PEMULWUY DEVELOPMENT (Precinct 3) – Design Review Panel Meeting No.6

DATE: 10/04/2017

5.4 Panel Discussion/Recommendations		
5.4.1	The presentations today were a great development since the last meeting.	
5.4.2	DPRM6 to be the final review and the scheme good to submit pending the following suggestions.

Improvement on SEARs Form

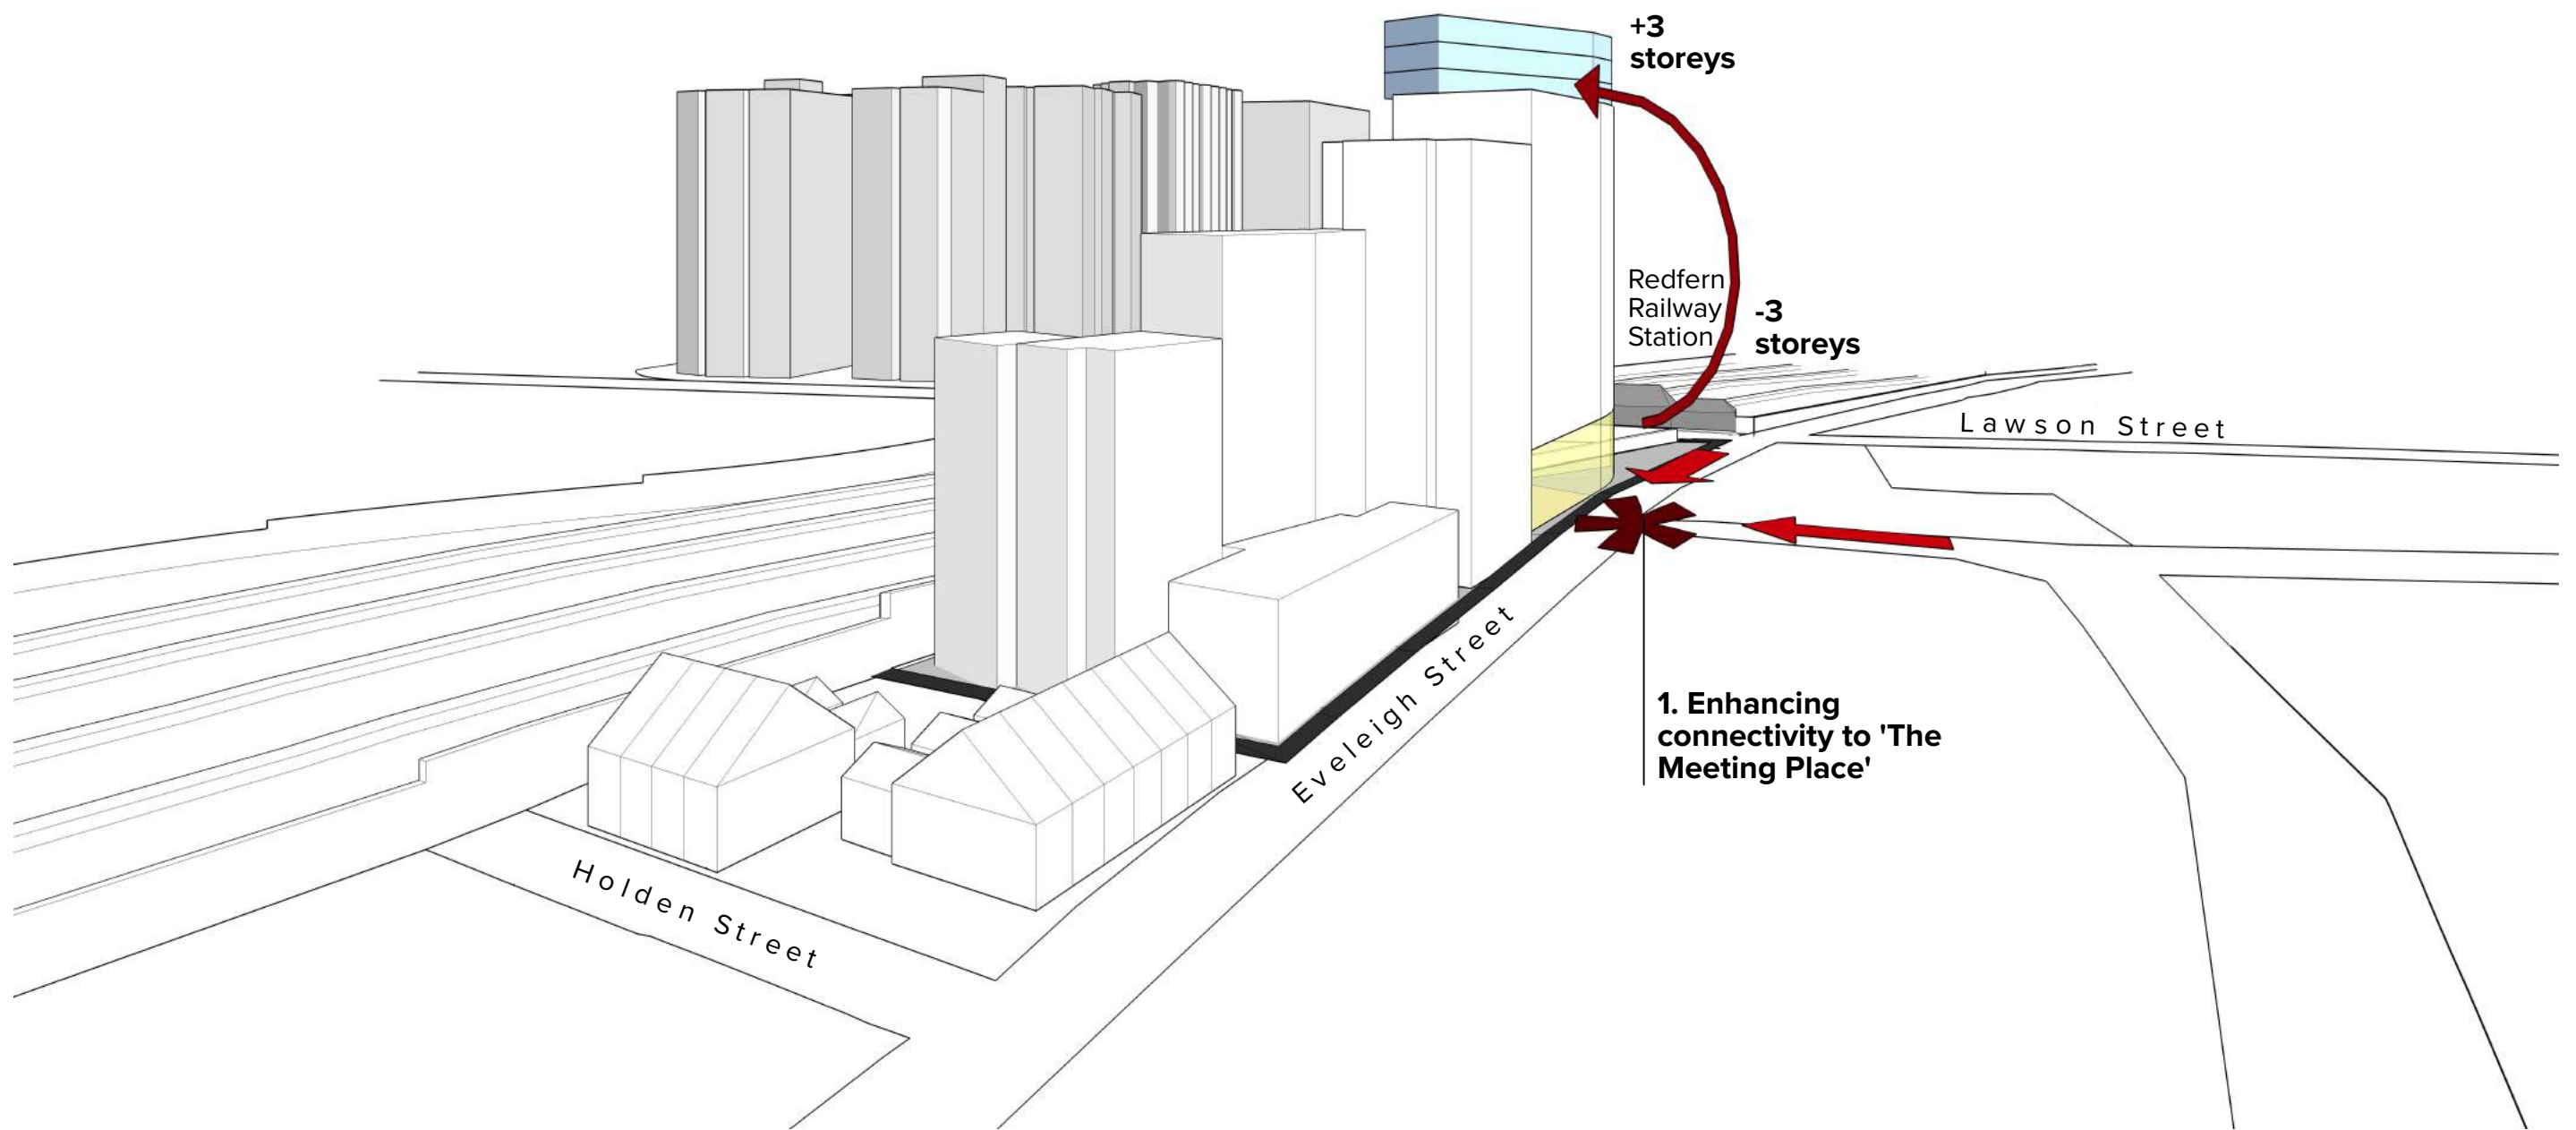
5.4.12	In the architectural report, clearly argue the case for moving away from the SEAR’s envelope. I.e. improved cross ventilation, light to internal corridors, better amenity to shared spaces, etc.

Public Domain Interface

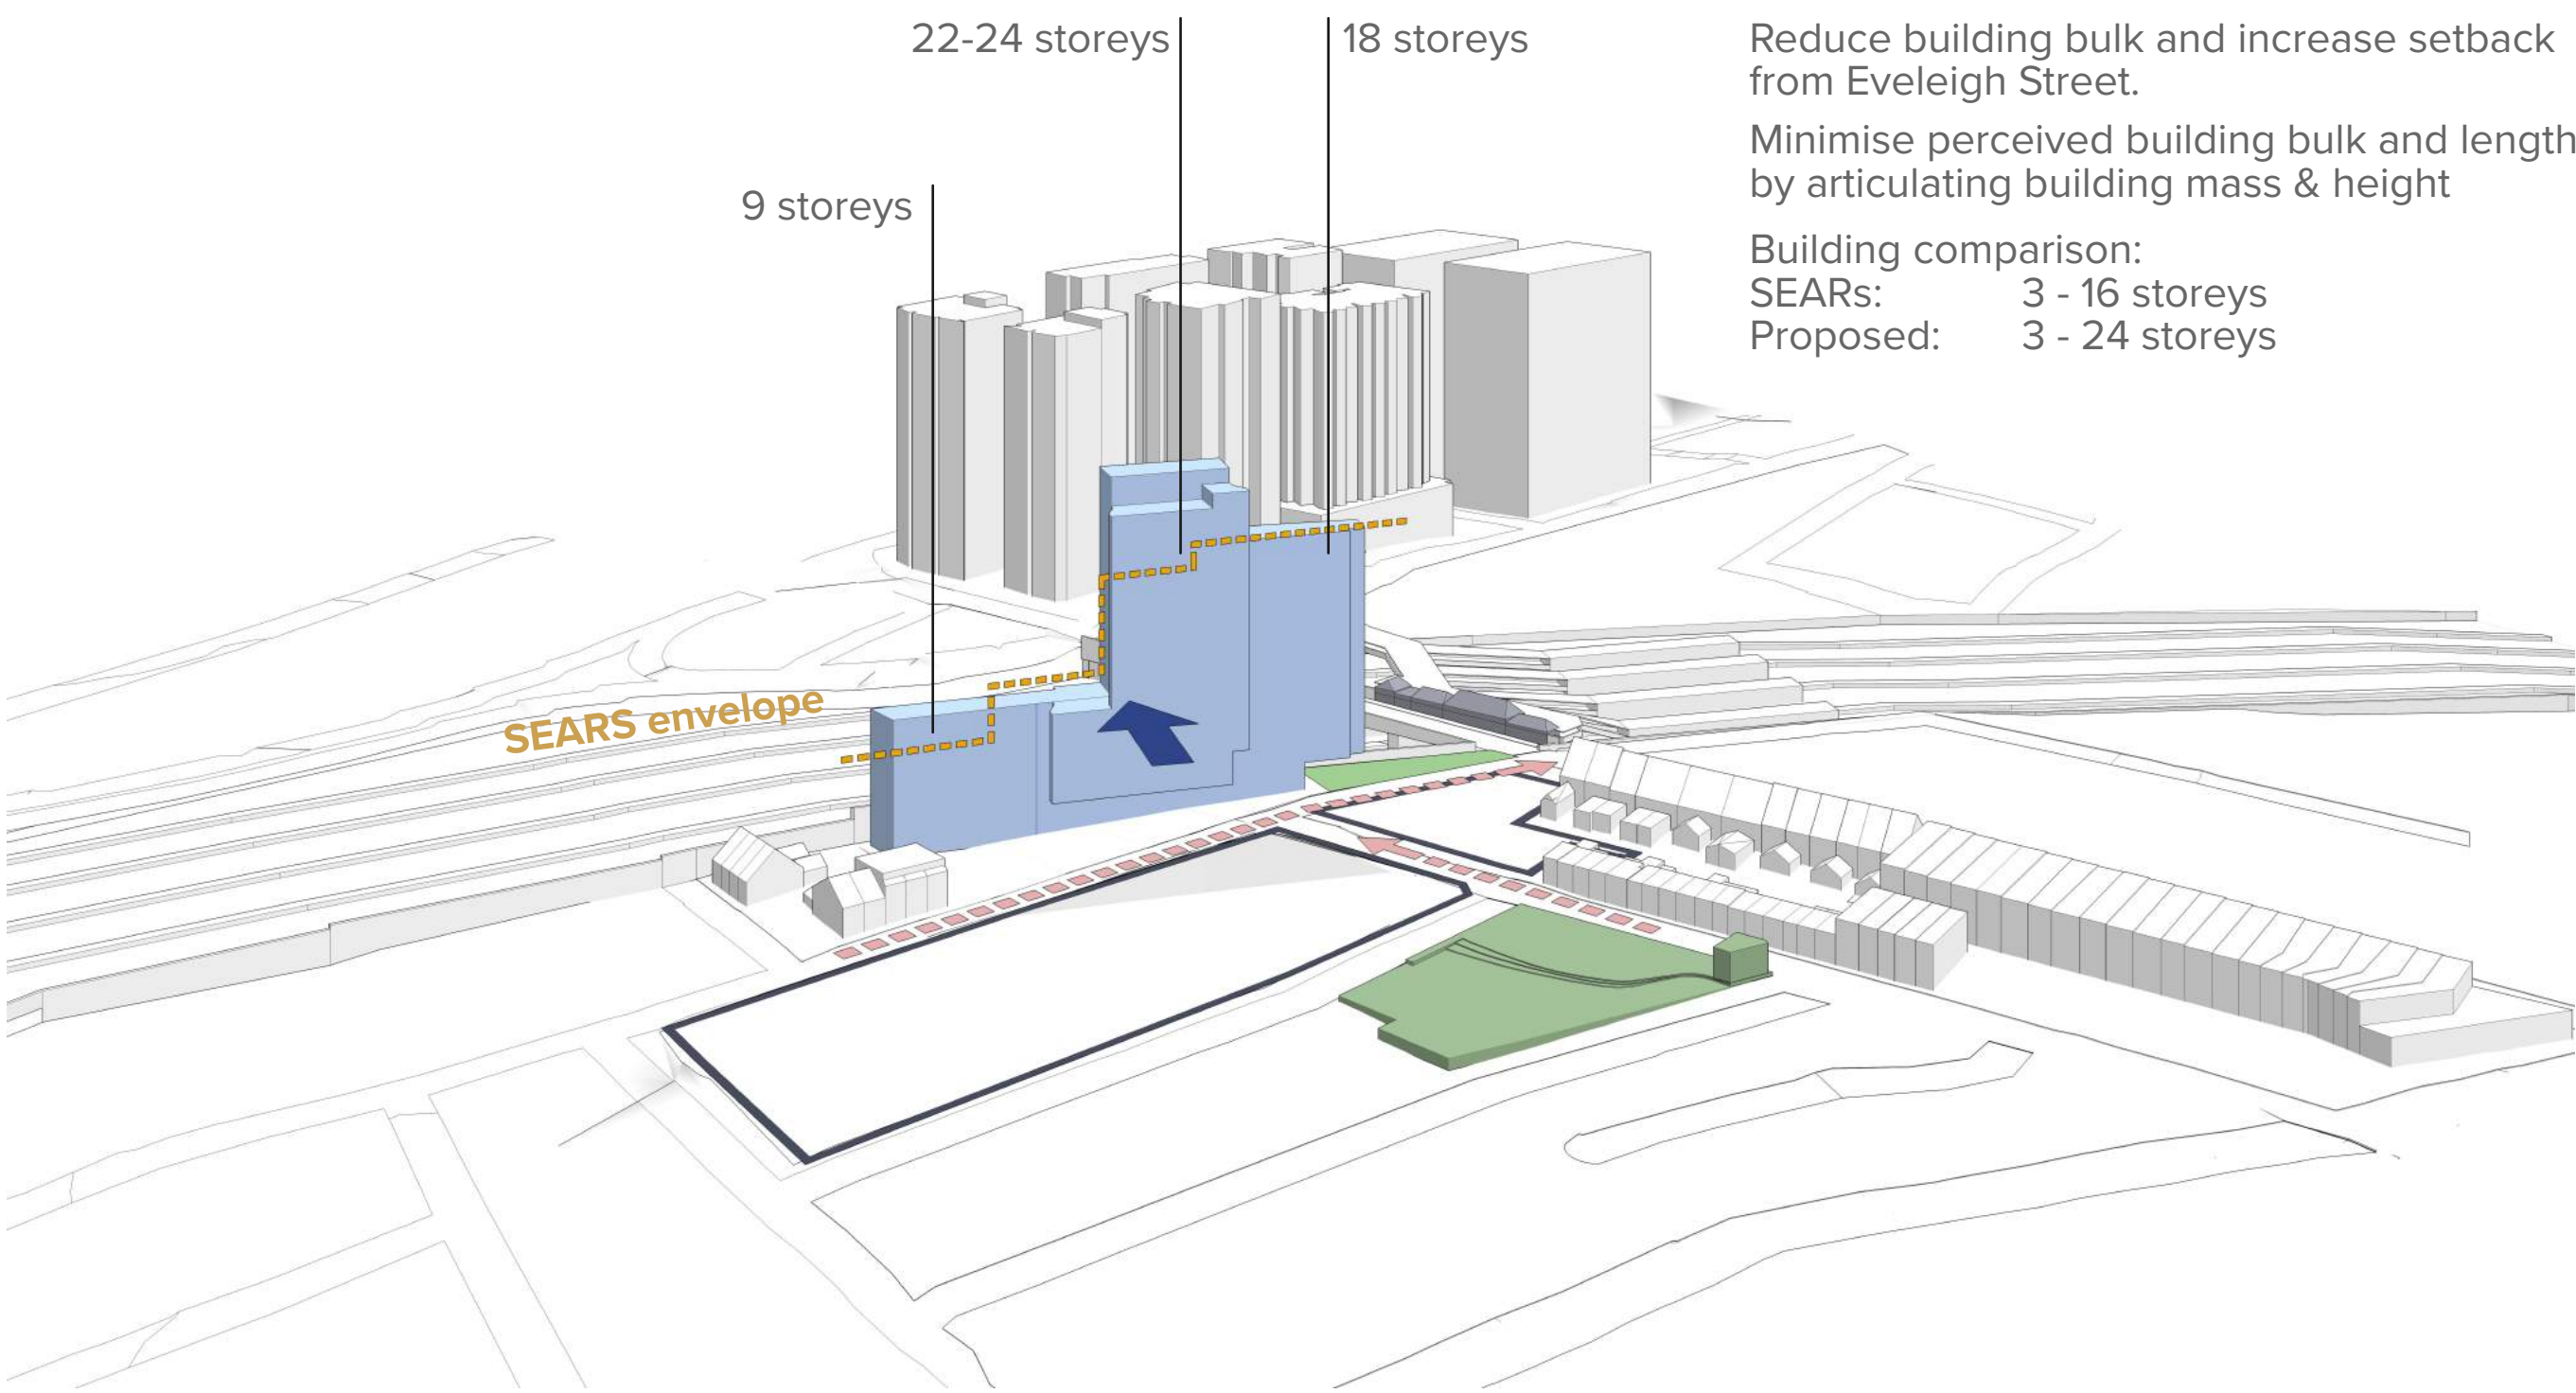
5.4.3	Secondary (student) entry to building. Footpath along Everleigh street is narrow. Provide a pause point at the entry via a recess in the glazing that currently sits flush with the site boundary. Suggest a seat and planting to soften the entry and provide additional footpath circulation space.

5.4.5	View from Caroline Street – further emphasis of the main entry on axis with Caroline Street is recommended.	
5.4.6	Improve the connection between the street / public open space and the ‘family room’ on the ground floor. This ‘edge’ to be investigated.

Built Form Articulation

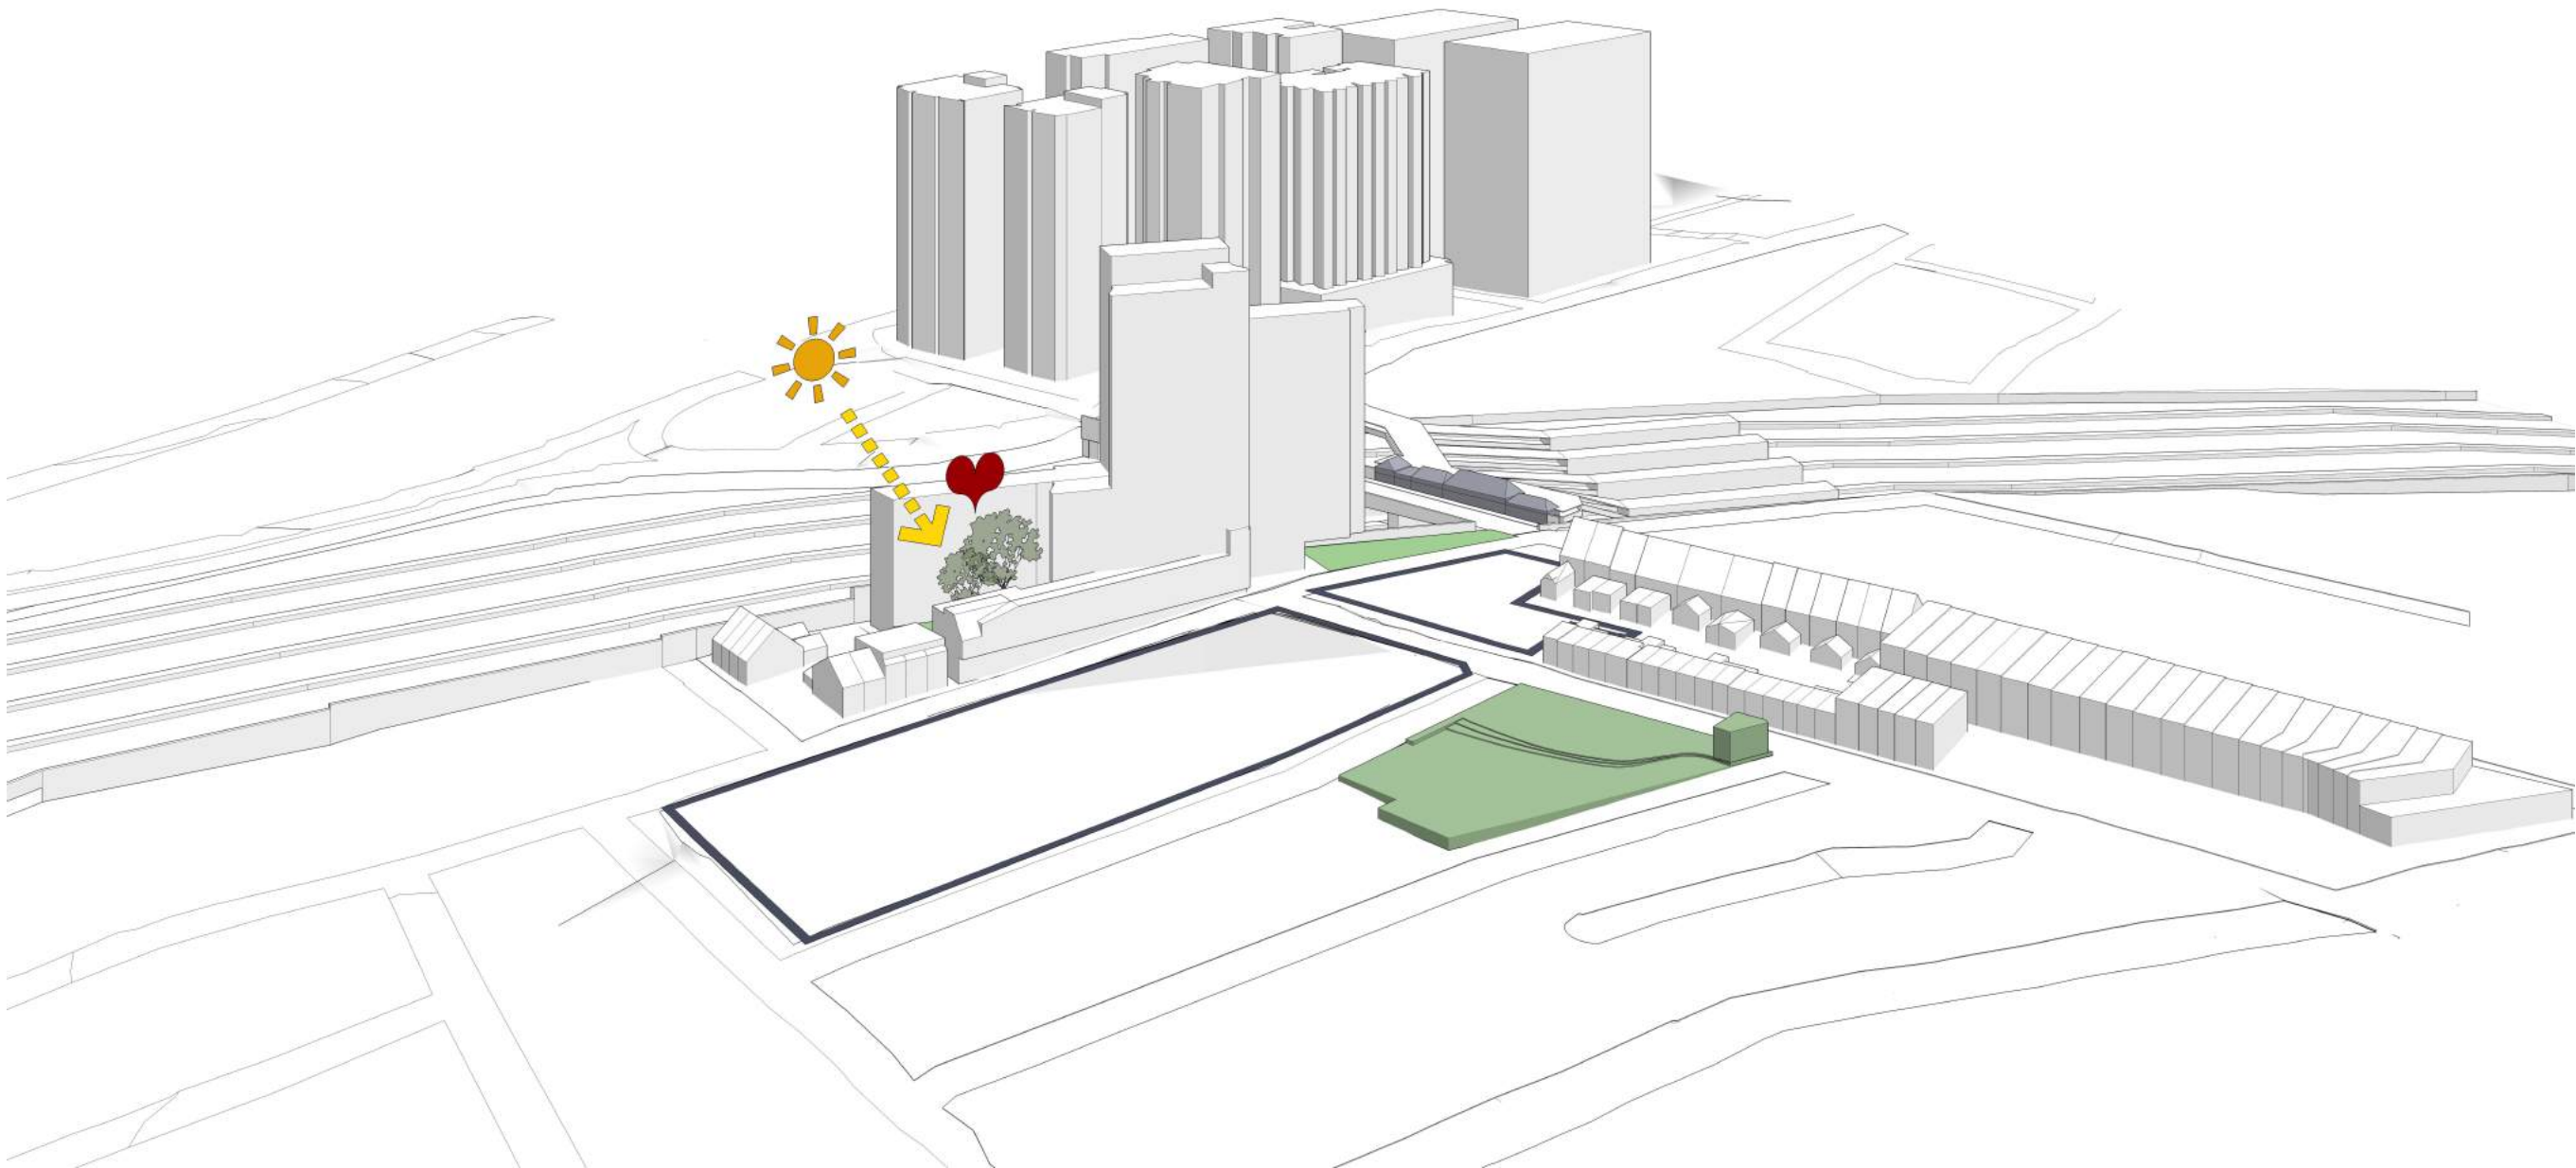
5.4.4	<p>Facade. The façade design along the low-rise section of the building remains too horizontal in emphasis. Further articulation and emphasis of the vertical is required to meet the stated design objective of relating to the finer grain and scale of the adjacent terrace housing.</p> <p>Suggest a green ‘eyebrow’ along the roof edge of the low rise to soften edges.</p> <p>The low rise is to have its own architectural language.</p> <p>Ensure the terracotta and proposed tile cladding is part of the cost plans.</p>
